Memo To: Jean Fraser
Barbara Barhydt
From: David Margolis-Pineo
RE: Development Review Comments for 118 Congress St.

The Department of Public Services has the following comments for the proposed project located at 118 Congress Street.

SUBDIVISION RECORDING PLAT
C1.0

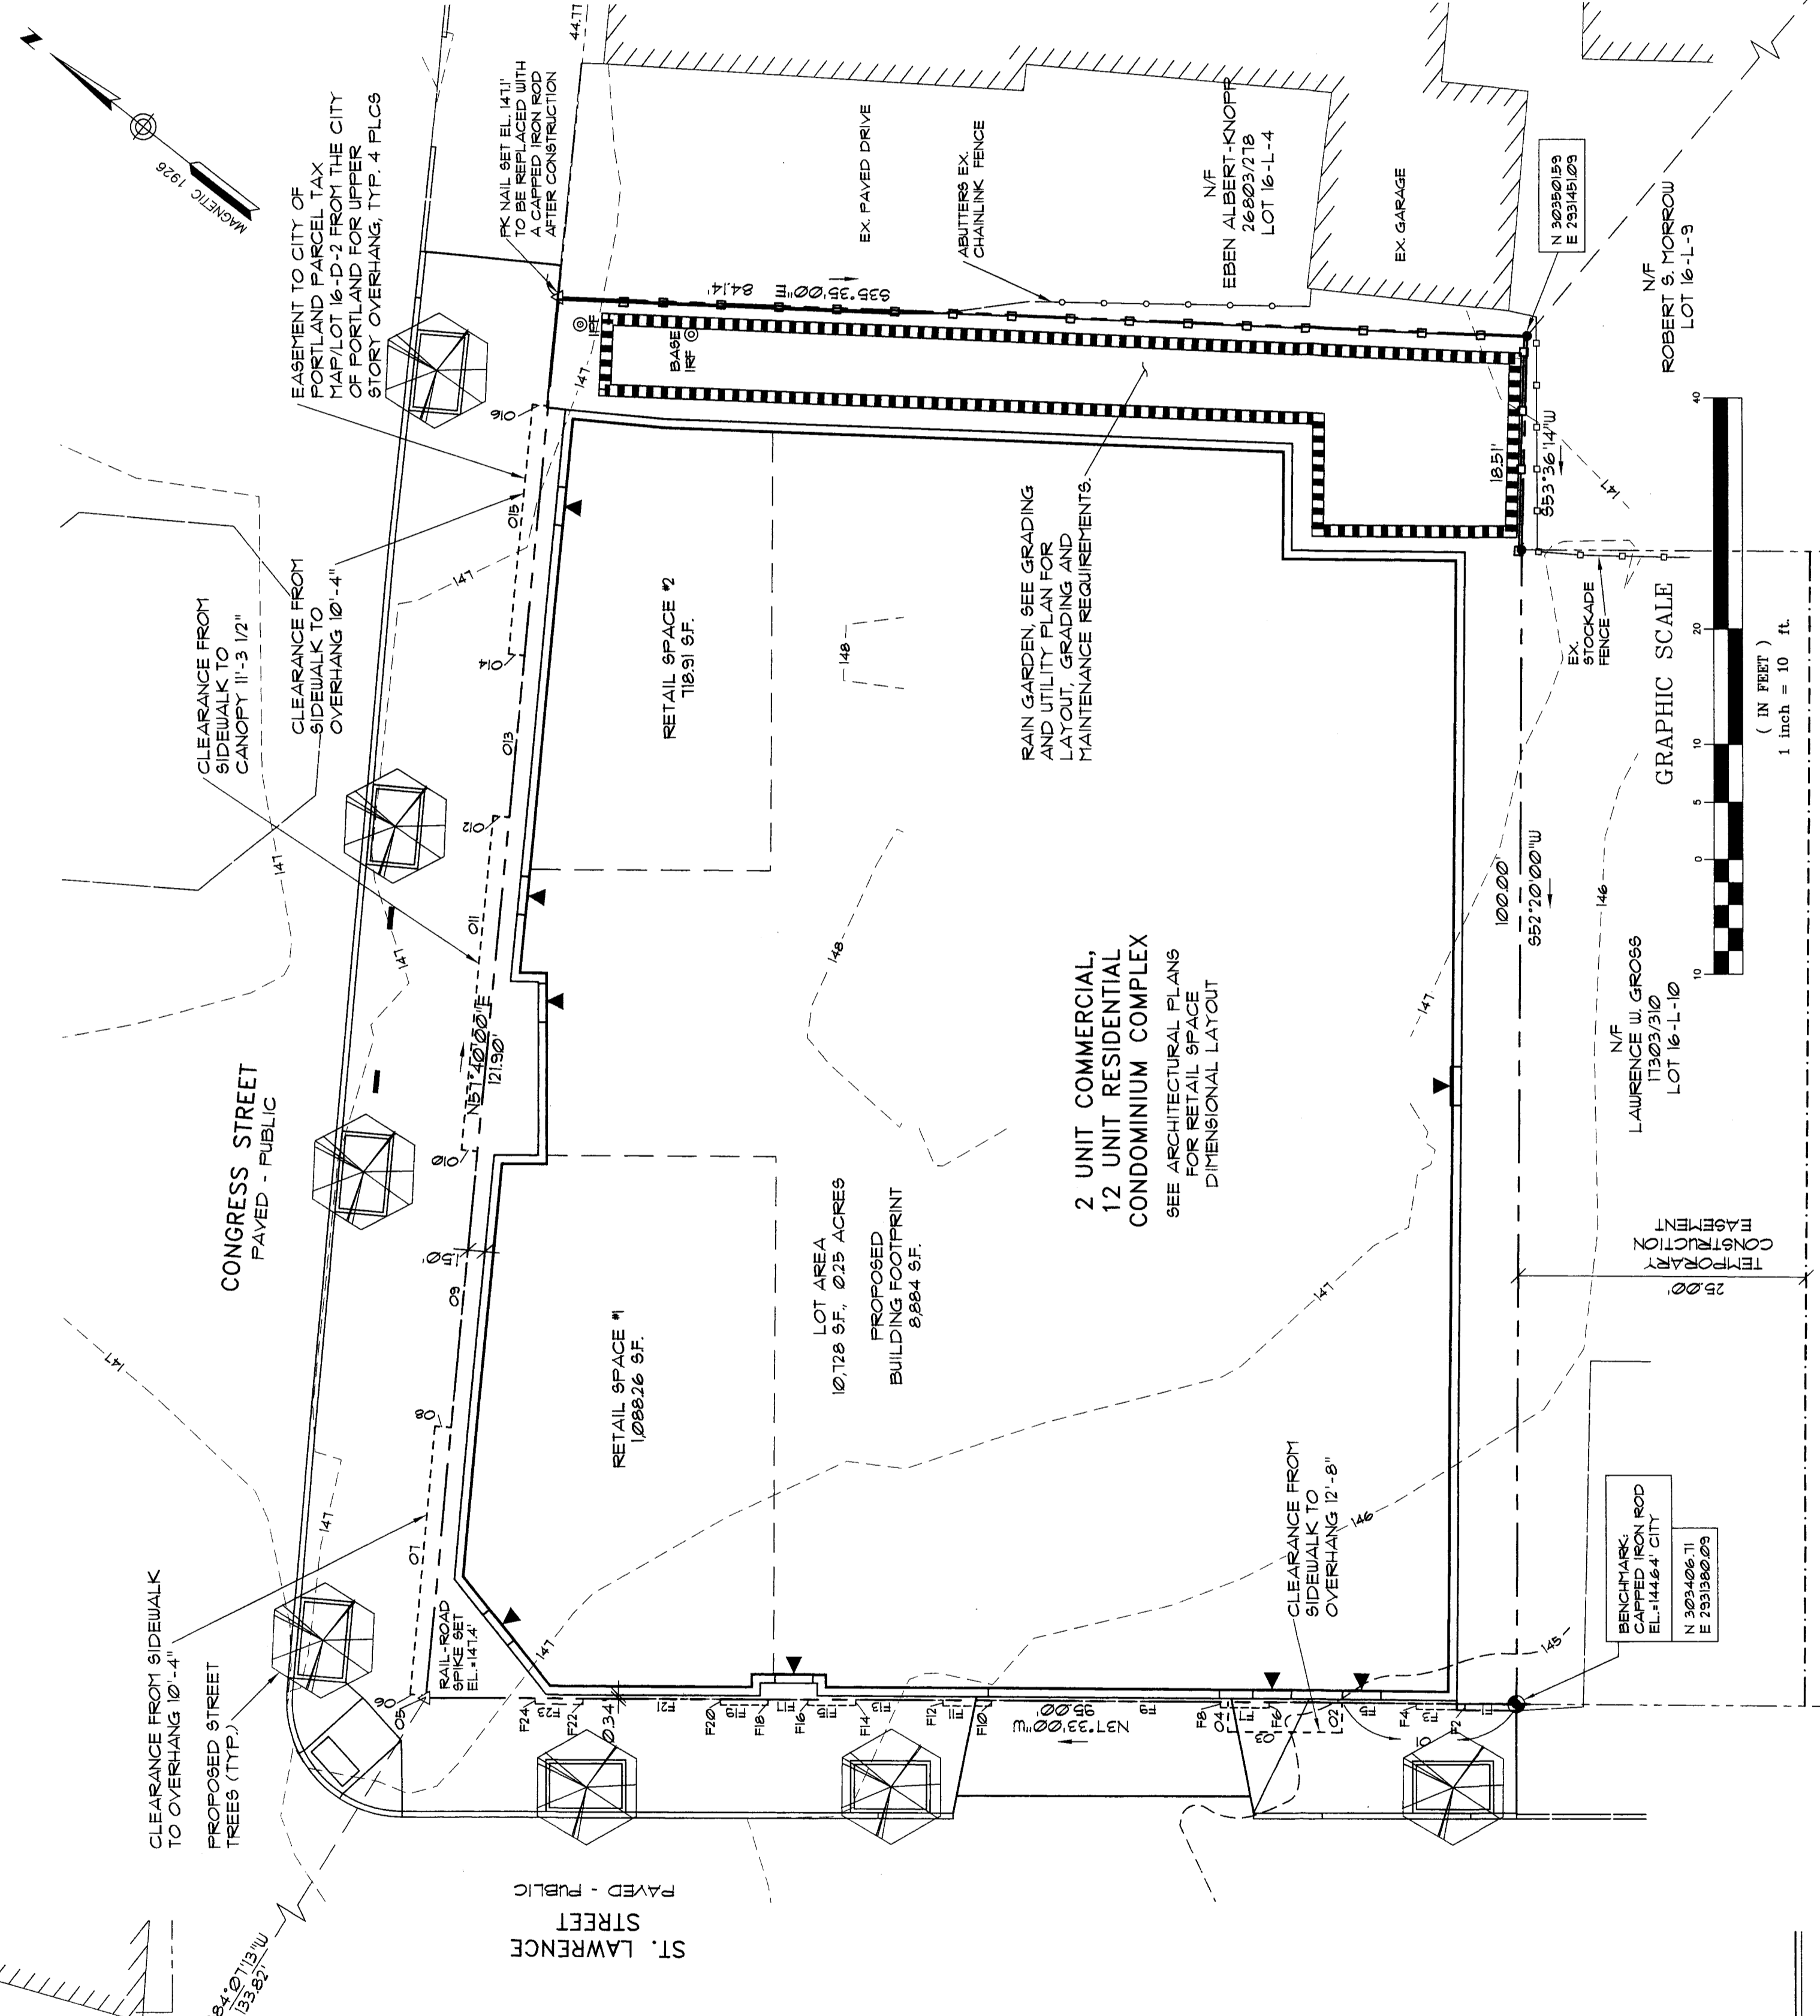
2. Add State Plane Coordinates for the four property corners.
Not complete.
3. Provide survey pins to all property corners once construction is completed.
No indication that this condition will be met.

4. It is expected that the foundation footing will encroach the street right of way. A city license will be required **with a metes and bounds description.**
This issue has not been addressed.

13. **The Subdivision Recording Plat is required to be stamped by a registered Land Surveyor.**
14. **The applicant is proposing flush granite and concrete pavers in the sidewalk area within the road right of way. This Department is not averse but the City Council will need to OK the request change of sidewalk material which goes against City policy.**

1 NORTH ELEVATION
1/8" = 1'-0"

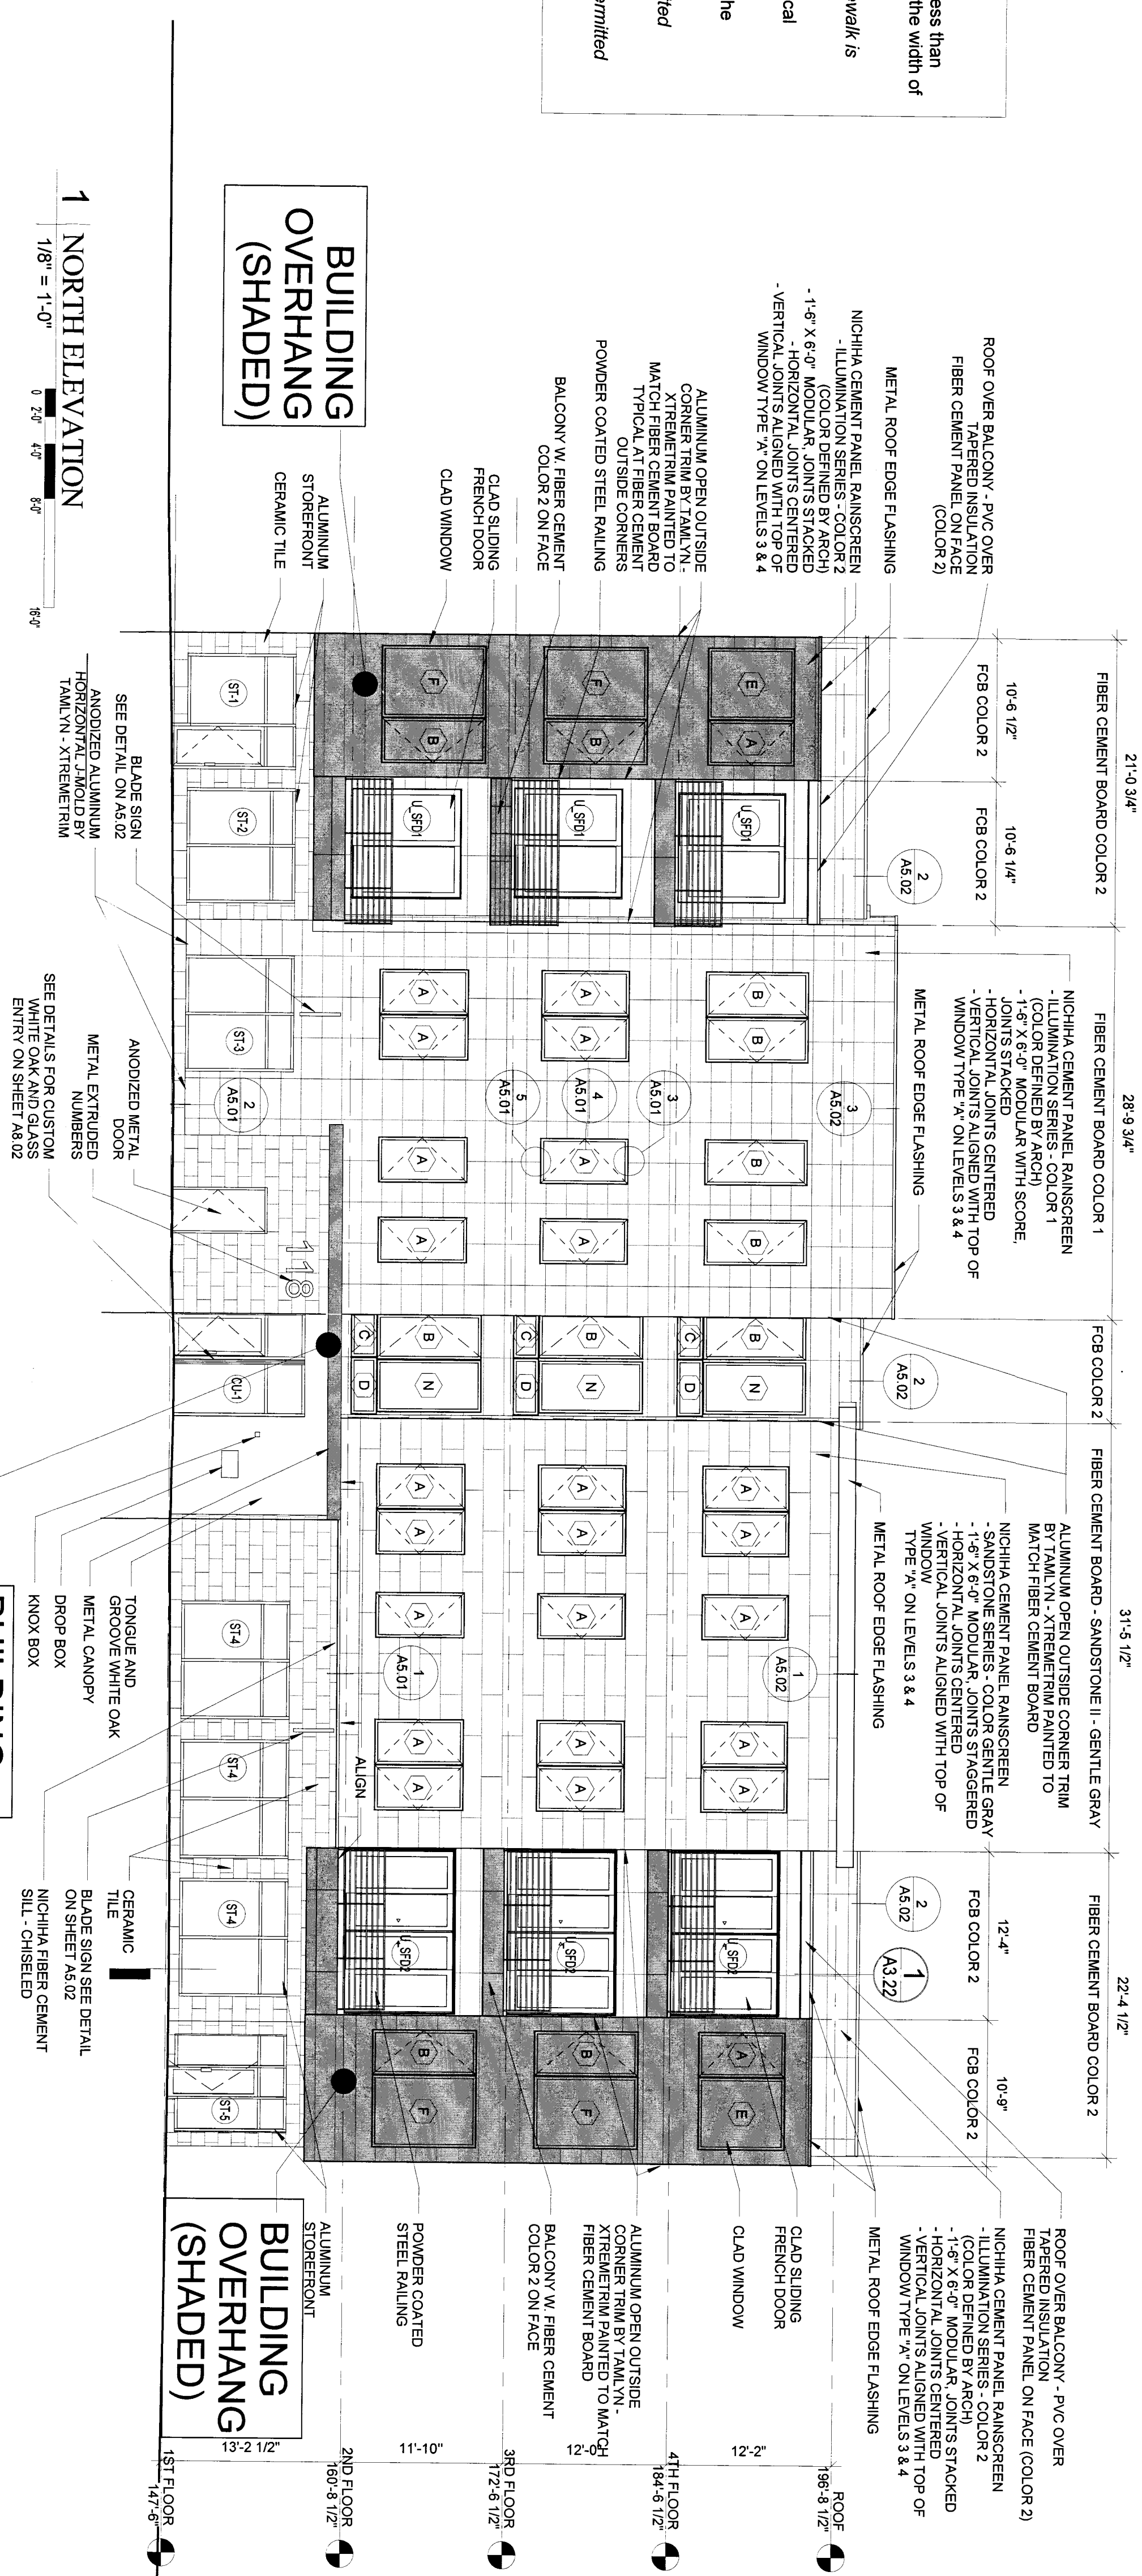
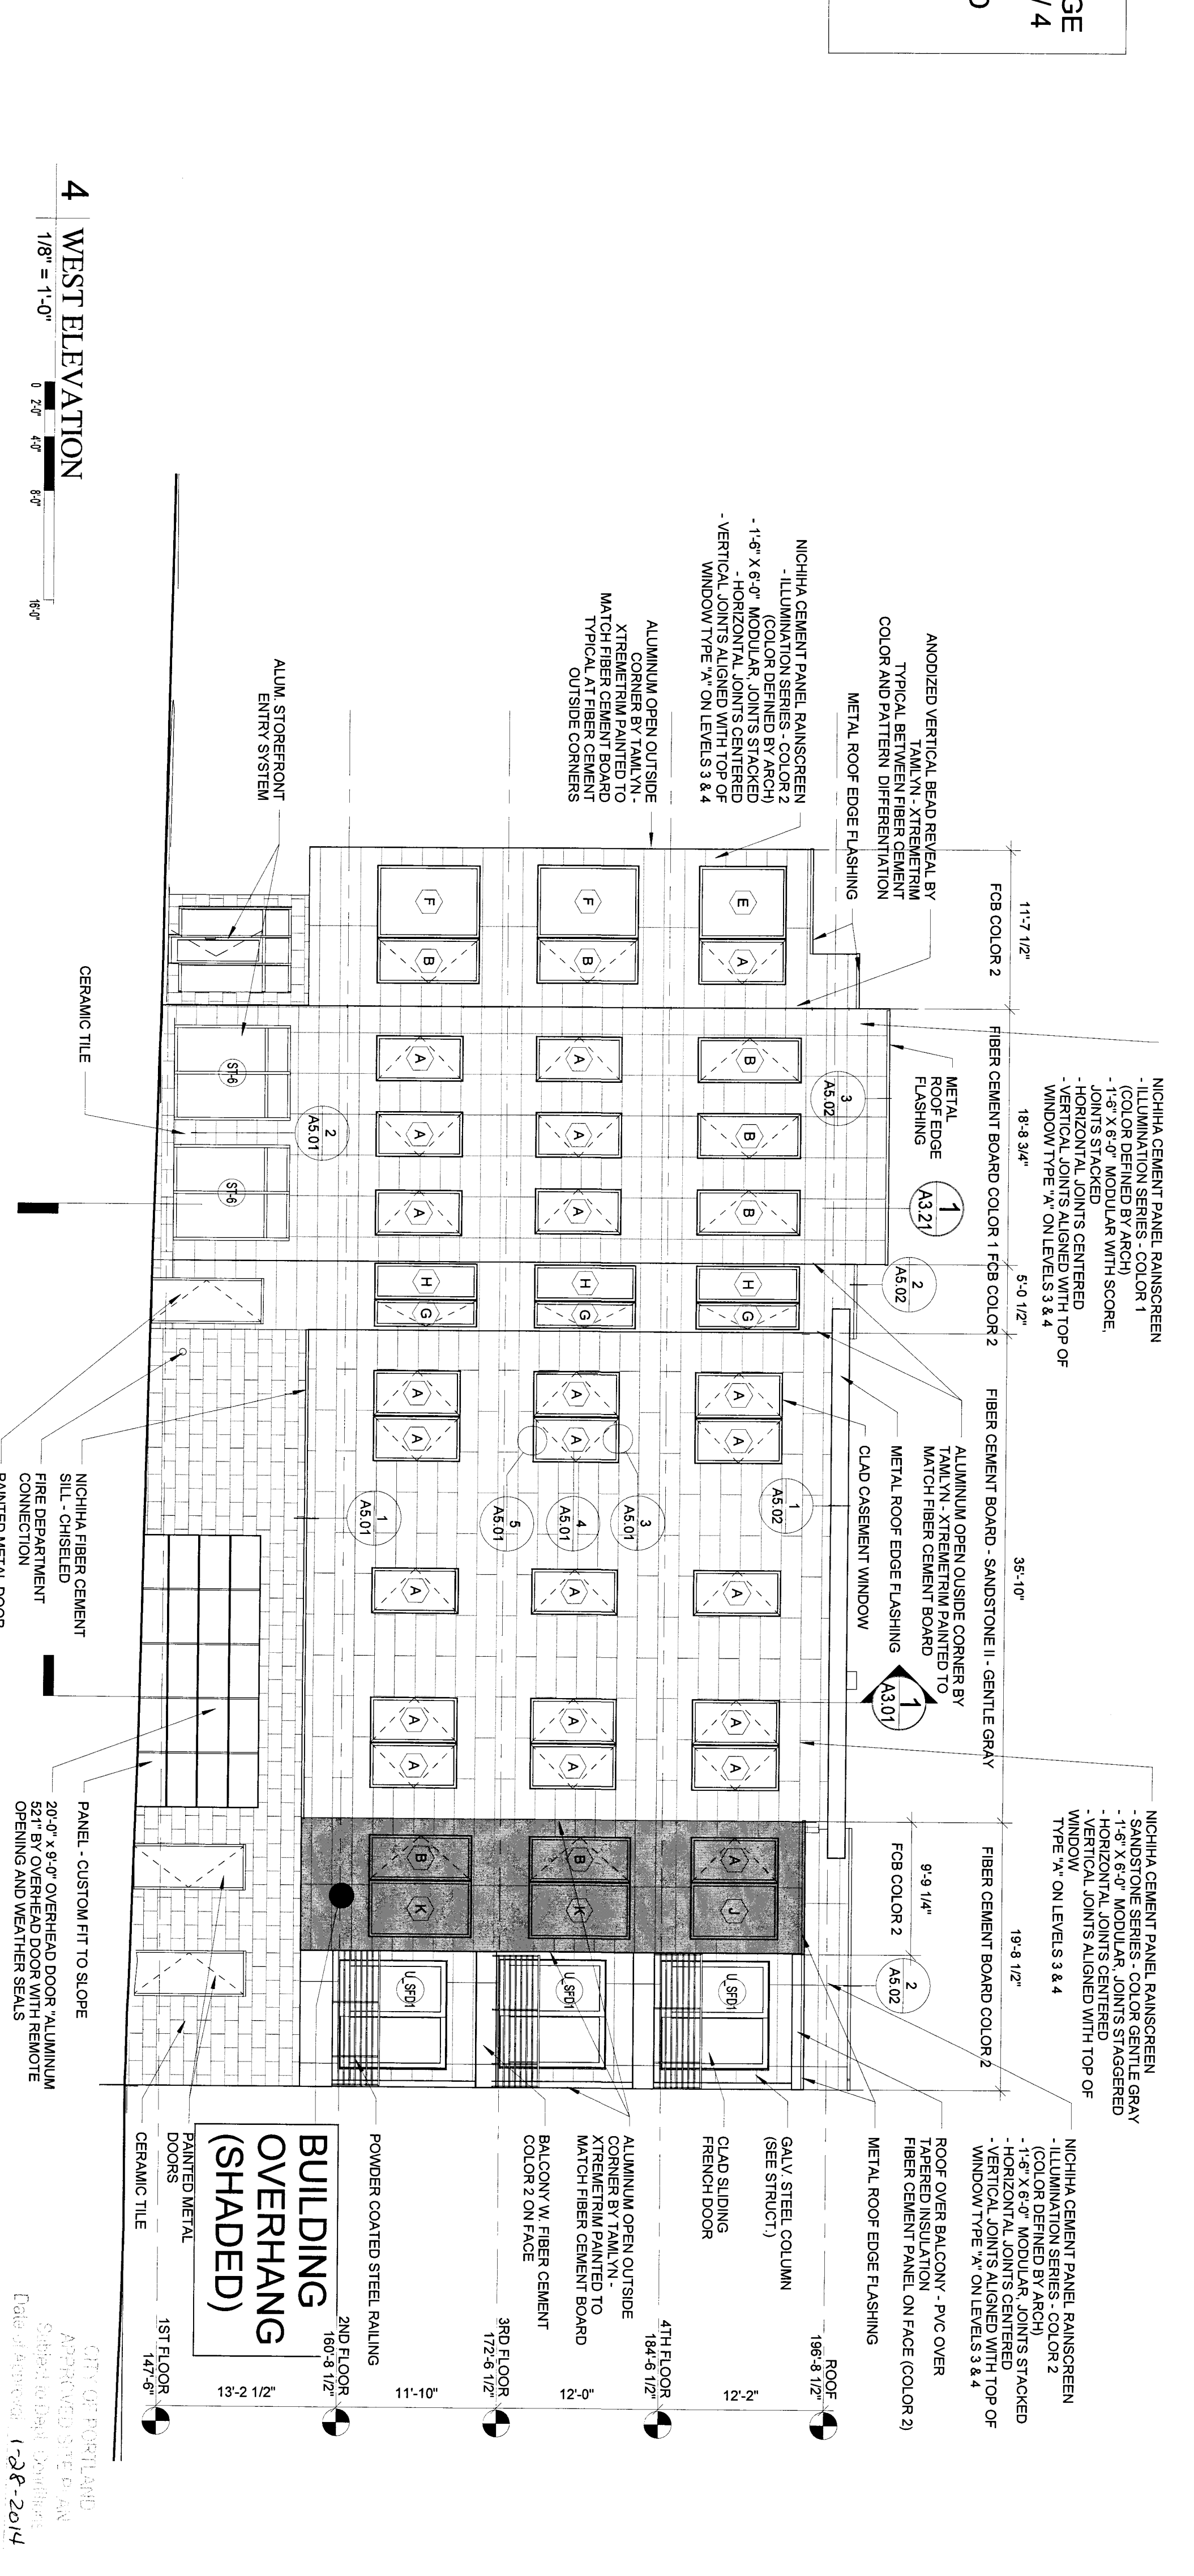
5. A city license will also be required for all proposed portions of the building overhanging the street right of way. The proposed areas encroaching into the Congress and St Lawrence St right of way are excessive and should be scaled back or the building should be set back to accommodate these features. Falling ice and snow is a pedestrian safety issue.
The Department of Public Services is not supportive of the proposed building encroachments of the street right of way for this project. We suggest the building be set back to allow the projections which do not encroach the street right of way. It is requested that the applicant address the issue of snow removal on the deck areas since retail is proposed on the first floor along the sidewalk area.
